RECEIVED
NOV 22 2024
Kittitas County CDS

Kittitas County Community Development Services grants *preliminary approval* of the Sparks Short Plat, SP-23-00009, based on the above staff analysis, findings of fact, and conclusions with the following conditions of approval.

SP 23 - 00009

BOWERS ROAD SHORT PLAT
PART OF SECTION 26, T. 18 N., R. 18 E., W.M.
KITTITAS COUNTY, WASHINGTON

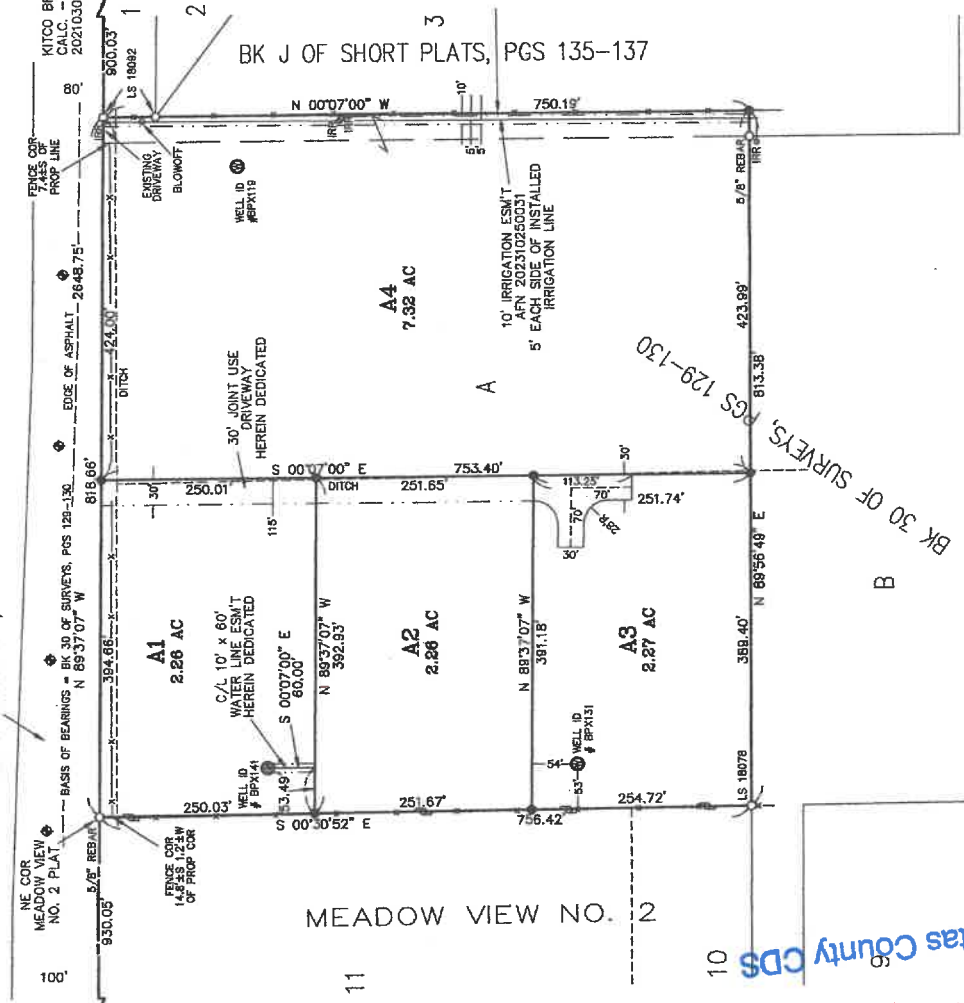
- A. Interior property corners will need to be set and shown on the final Short Plat.
- B. Please include language showing the 30' Joint Use driveway Easement as either existing, herein dedicated, or created by separate document.
- C. Please include suitable information for the accurate retracement of the 30' wide

Joint Use Driveway Easement... particularly in the turnaround area.
